Application for a non-material amendment following a grant of planning permission. Town and Country Planning Act 1990

| Street address: | <input type="text" value="E Entrance to Car Park From Comet Way"/> | | |

Planning approval has been given for the erection of a public house on the application site.

Drawing No. & Revision:
7127 - 432 - A

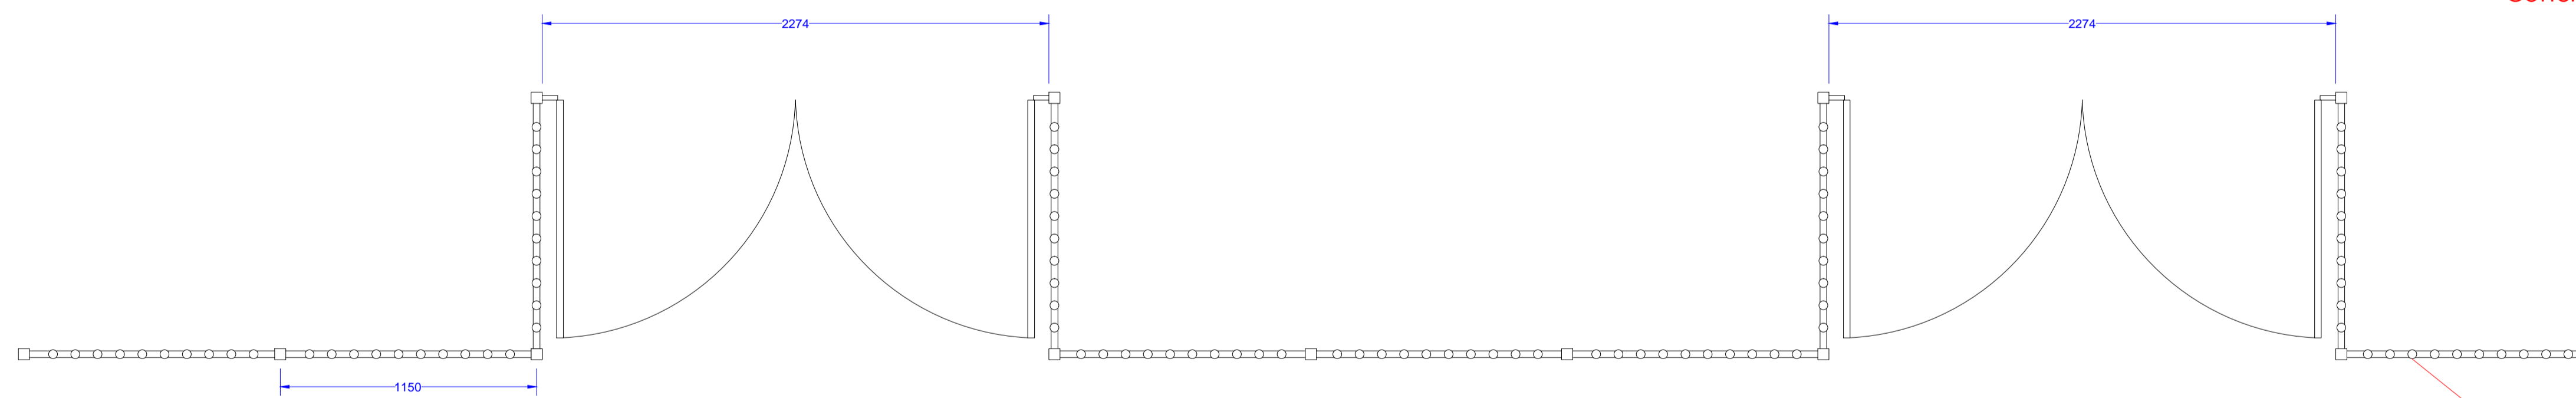
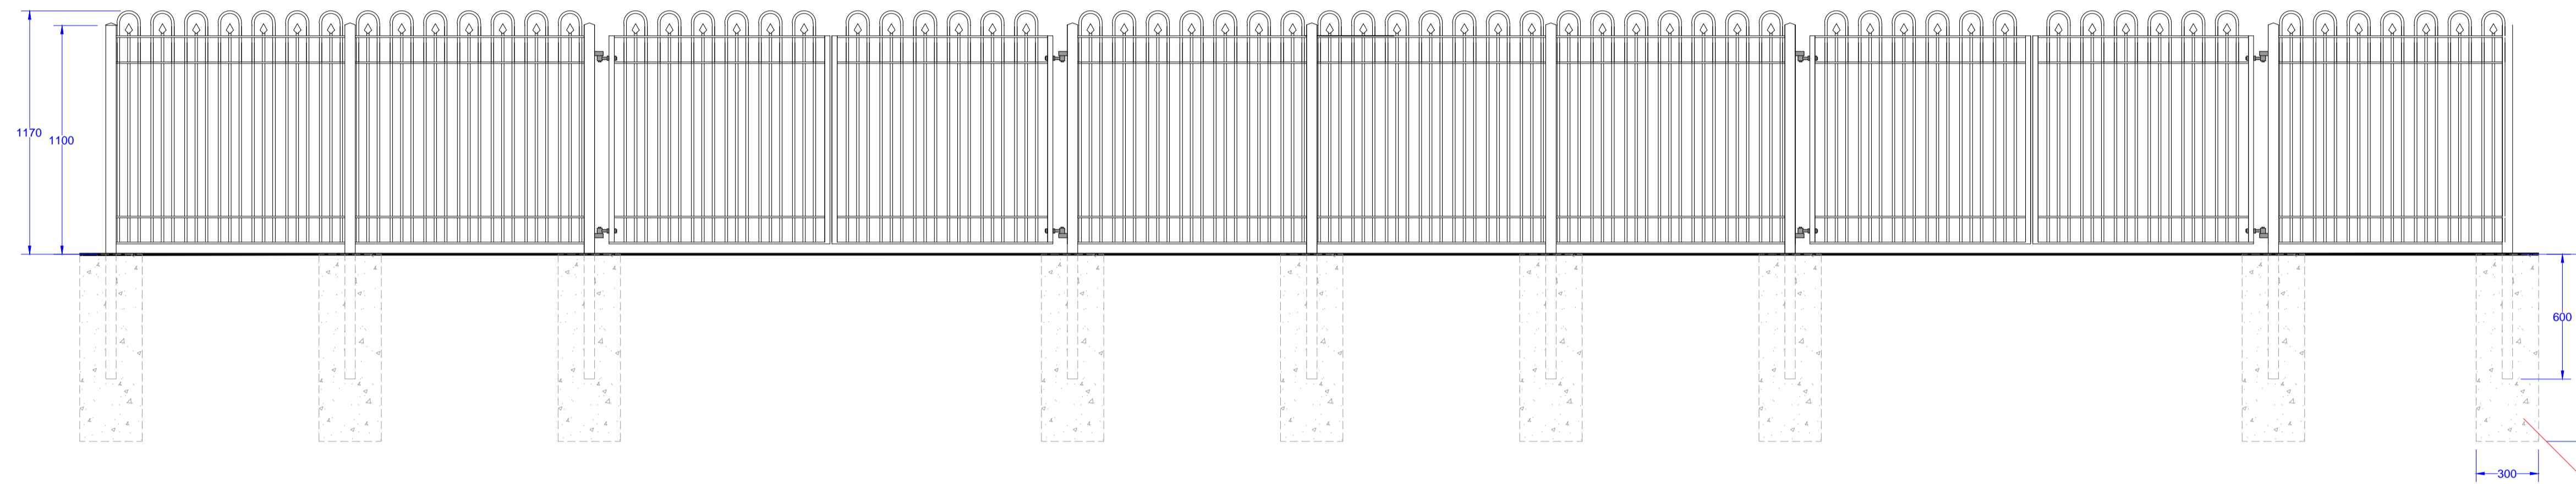
- Vertical and horizontal external and internal lattice beams removed where shown.
- External sun shades removed from above glazing.
- External stainless steel and glass balustrade removed and replaced with 1100mm powder coated stainless steel (as shown on plans).

Drawing Title:
Exterior Shelter

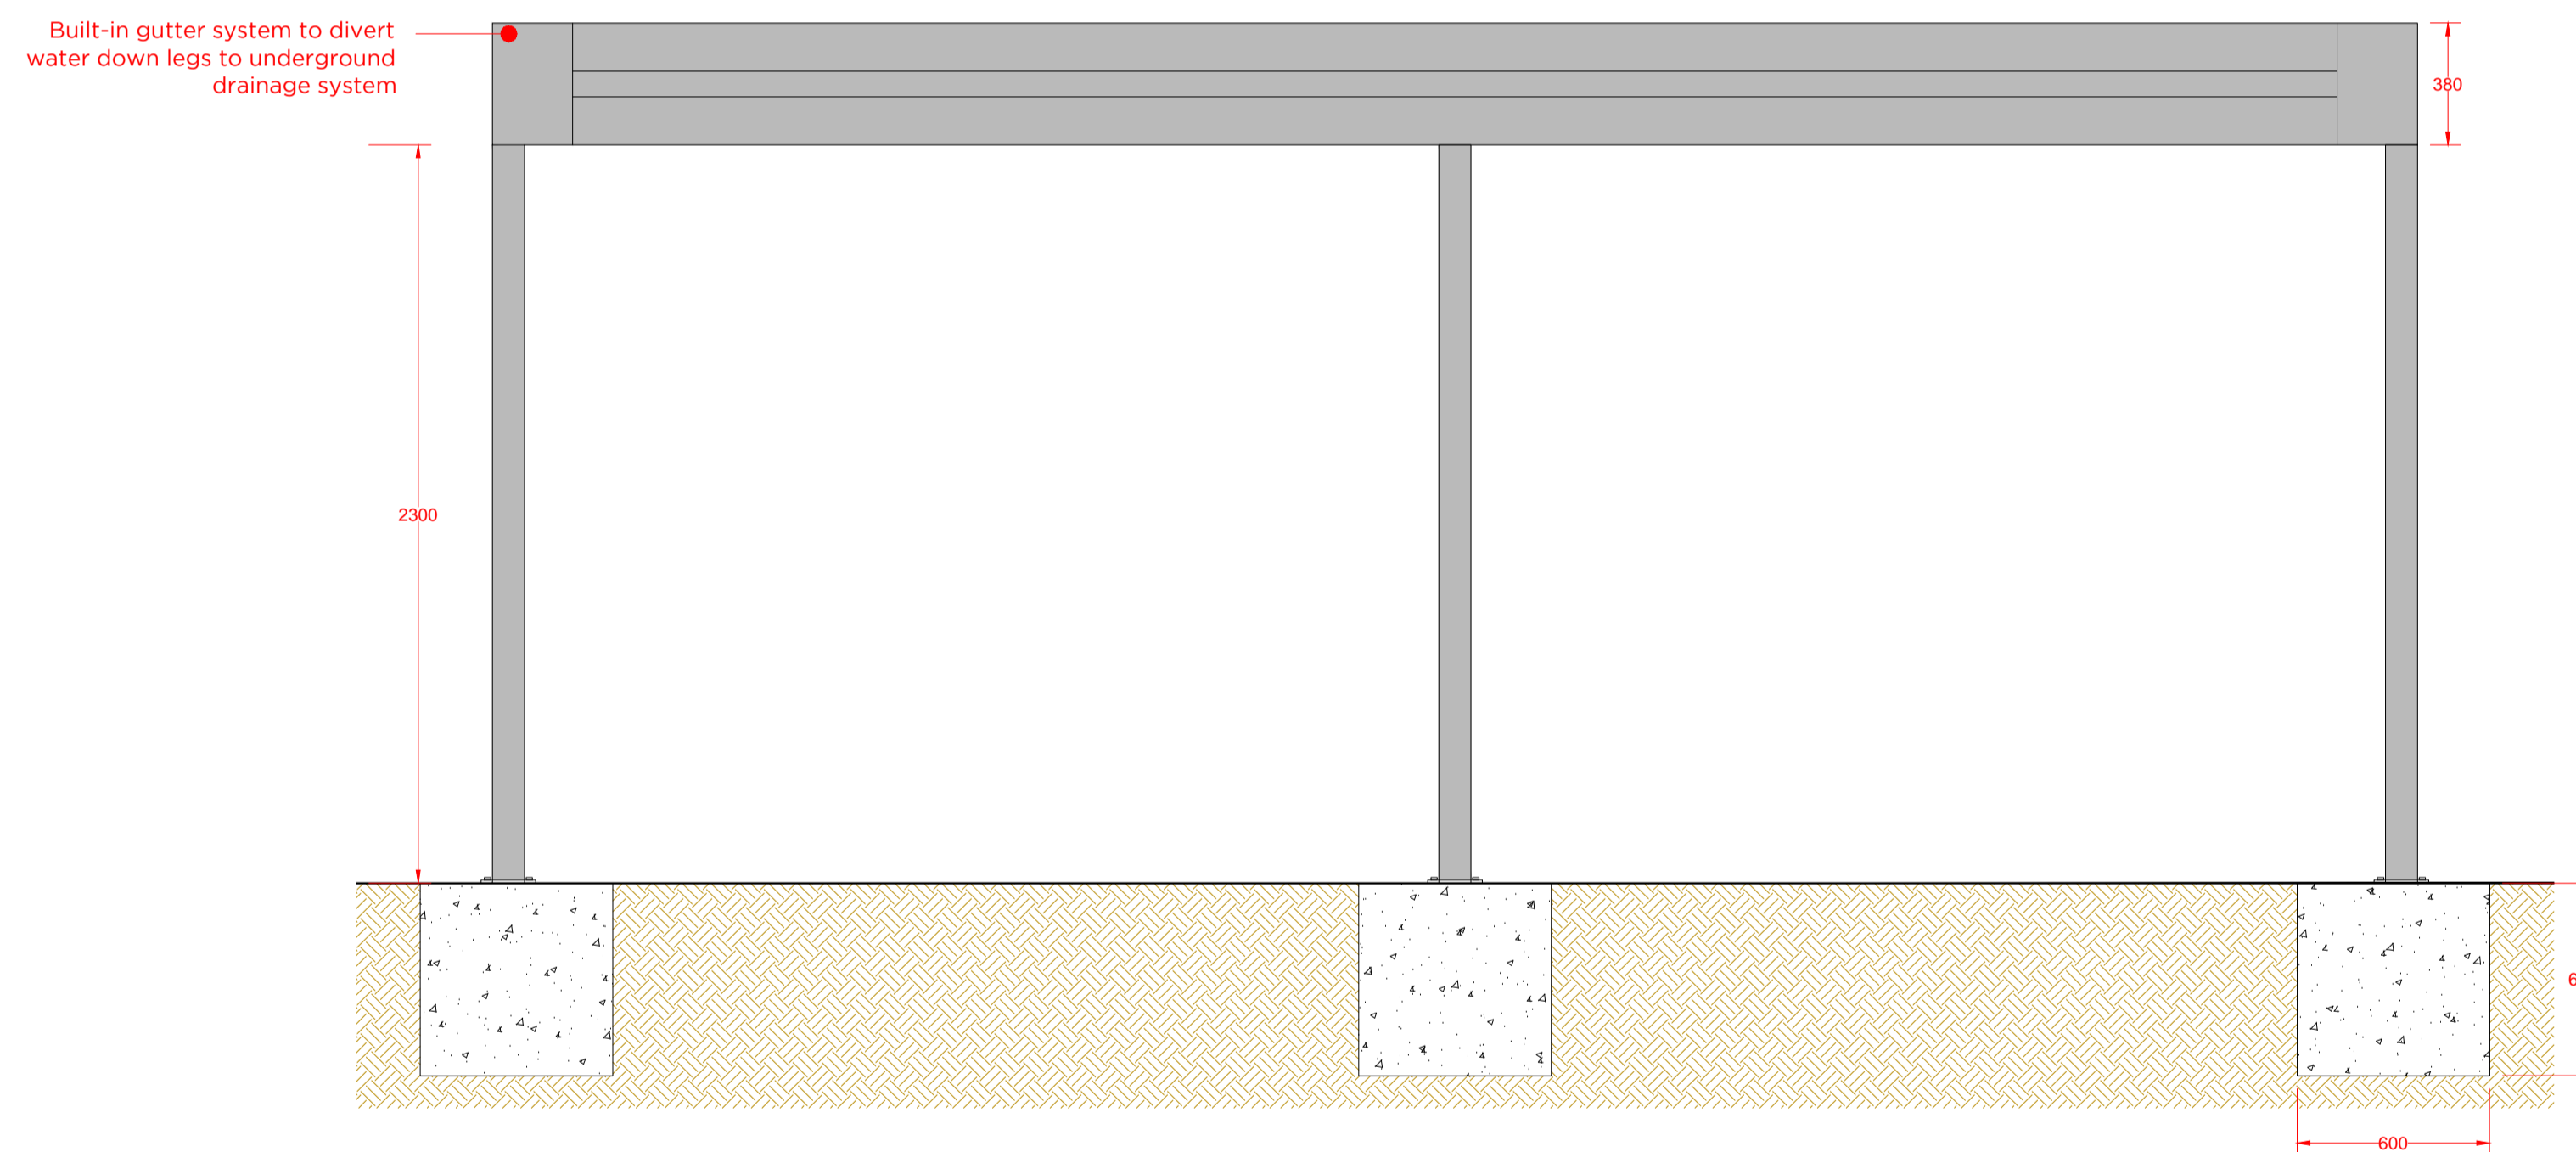
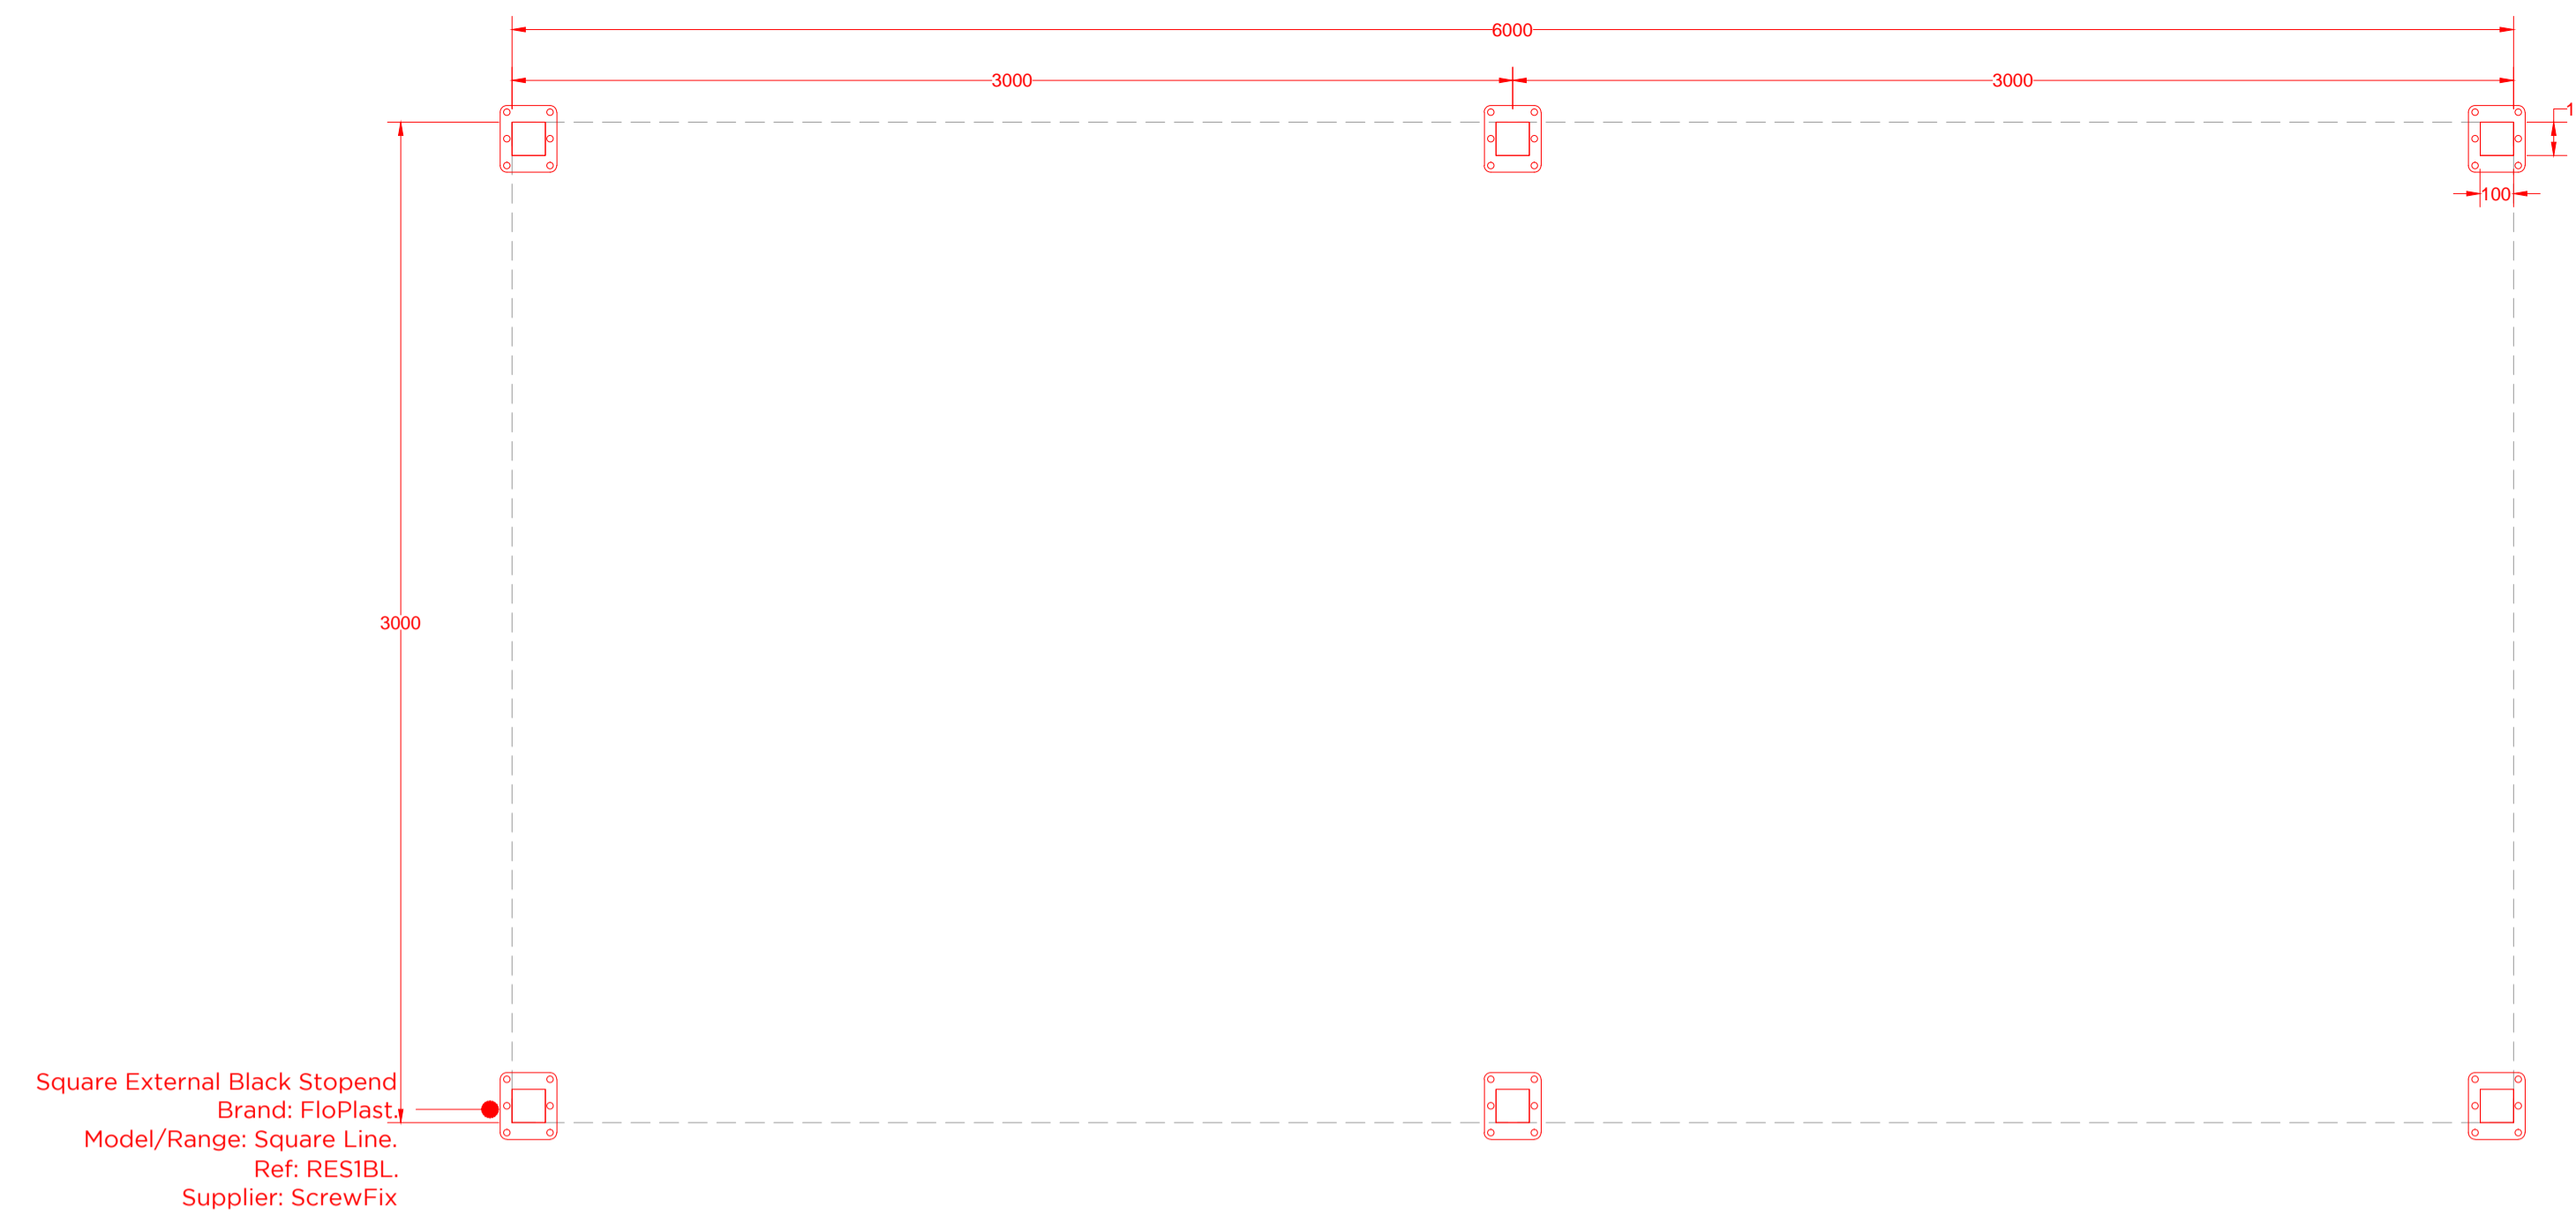
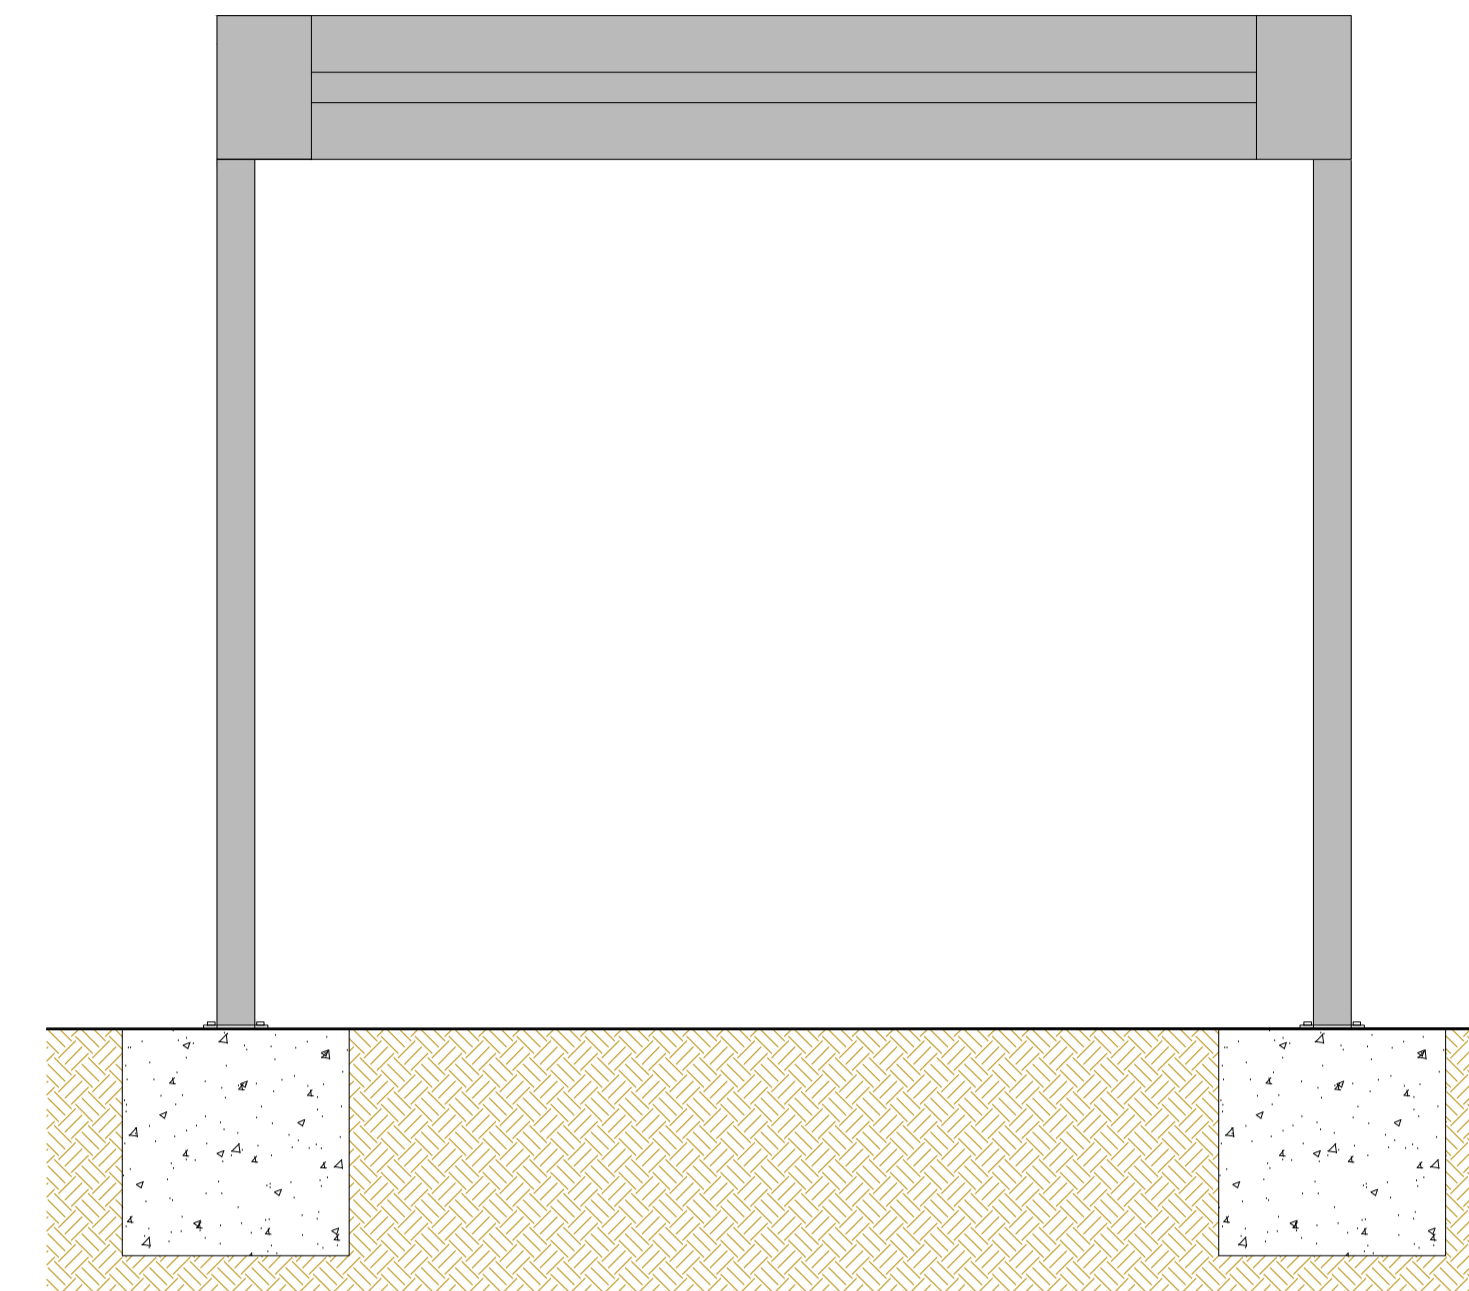
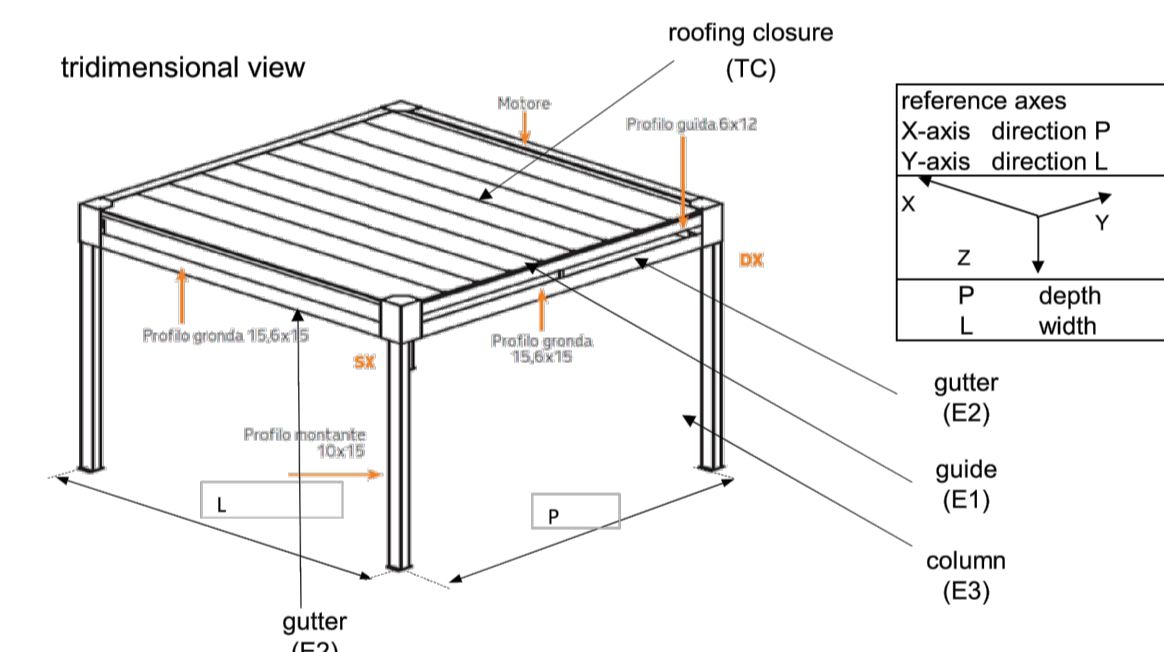
- Covered external smoking area changed and replaced with retractable covered area.
- External cladding changed to Marley Eternit Cedral Board (colour C54 - Pewter).
